R/215/25/HH

PL- rep [REDACTED]

**From:** [REDACTED]  
**Sent:** 08 December 2025 10:44  
**To:** Planning.Responses <Planning.Responses@arun.gov.uk>  
**Subject:** Re: Please find attached acknowledgement of Planning Application Comment - R/215/25/HH

Drawing:  
**Plans and elevations as proposed**

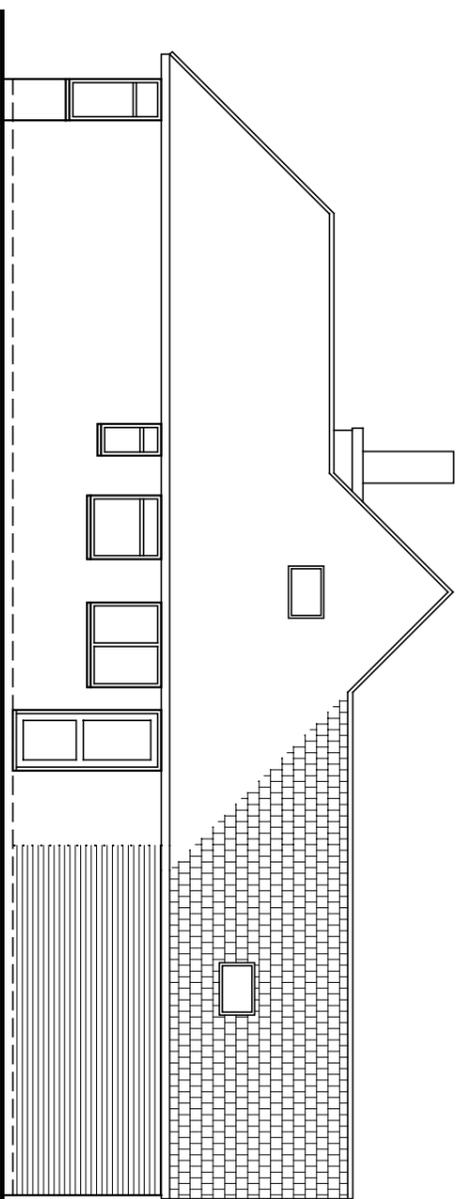
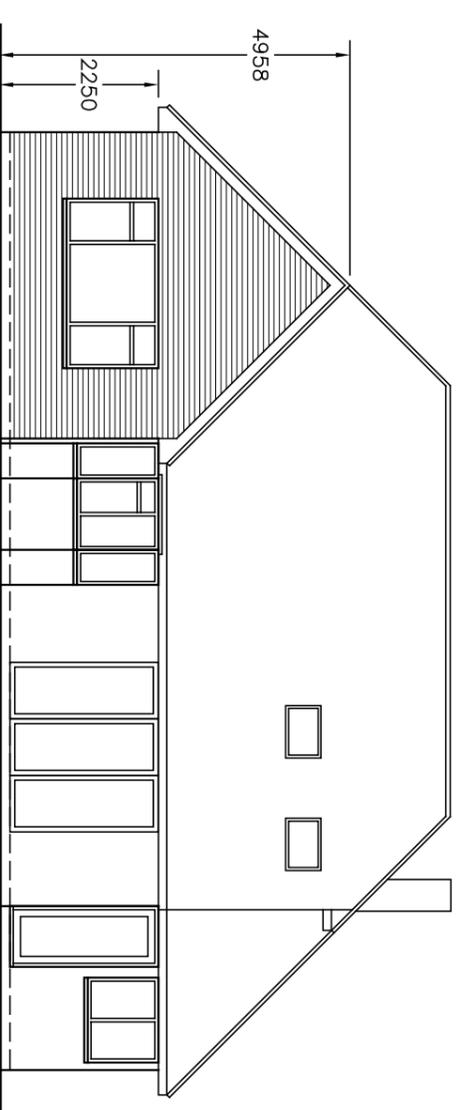
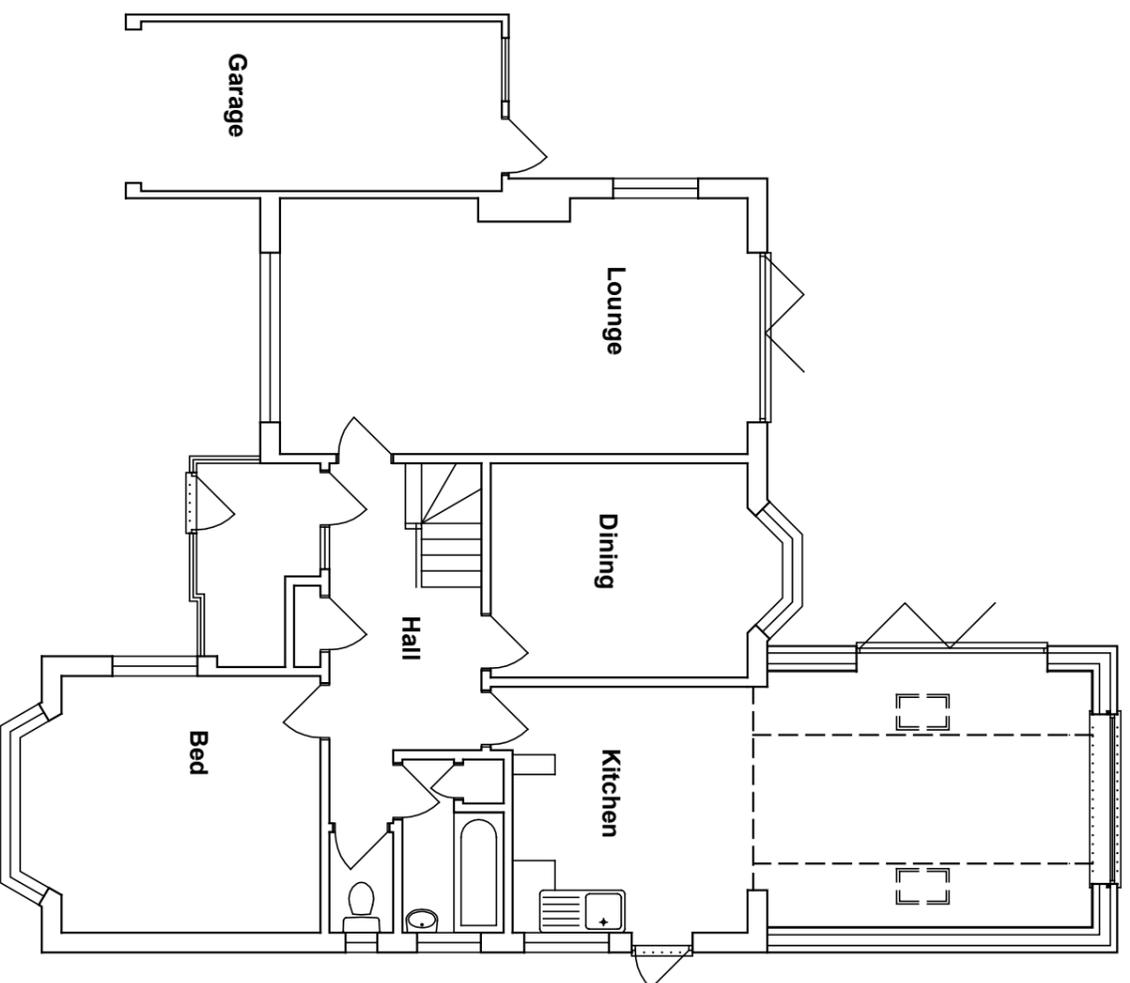
Could the planning department please take in to account and add to my application/comment ,  
45 DEGREE RULE ,FROM MY MAIN LIVING AREA AND OTHER ROOMS CLOSEST MAIN LIVING /  
SLEEPING AREA,,

THOMAS FAMILY PLAN TO BUILD EXTENSION /WALL/KITCHEN EXTENSION , ON MY SOUTH FACING BORDER  
WILL CAUSE A

PUSHING BACK MY HOME INTO RECESS,NOT IN KEEPING WITH NEIGHBOURHOOD , ,MAIN LIVING AND  
OTHER AREAS OF HOME,

TILES FROM ROOF COULD BE DAMAGING IN BAD WEATHER ,AS THEY WILL BE HEALTH HAZARD WHILE IN  
GARDEN,AND THREAT TO PROPERTY,

ALSO LIGHT FROM SKY RECESS INTERNAL LIGHT WOULD BE DIRECTLY INTO MY MAIN LIVING AREAS WHEN  
IN USE AT NIGHT
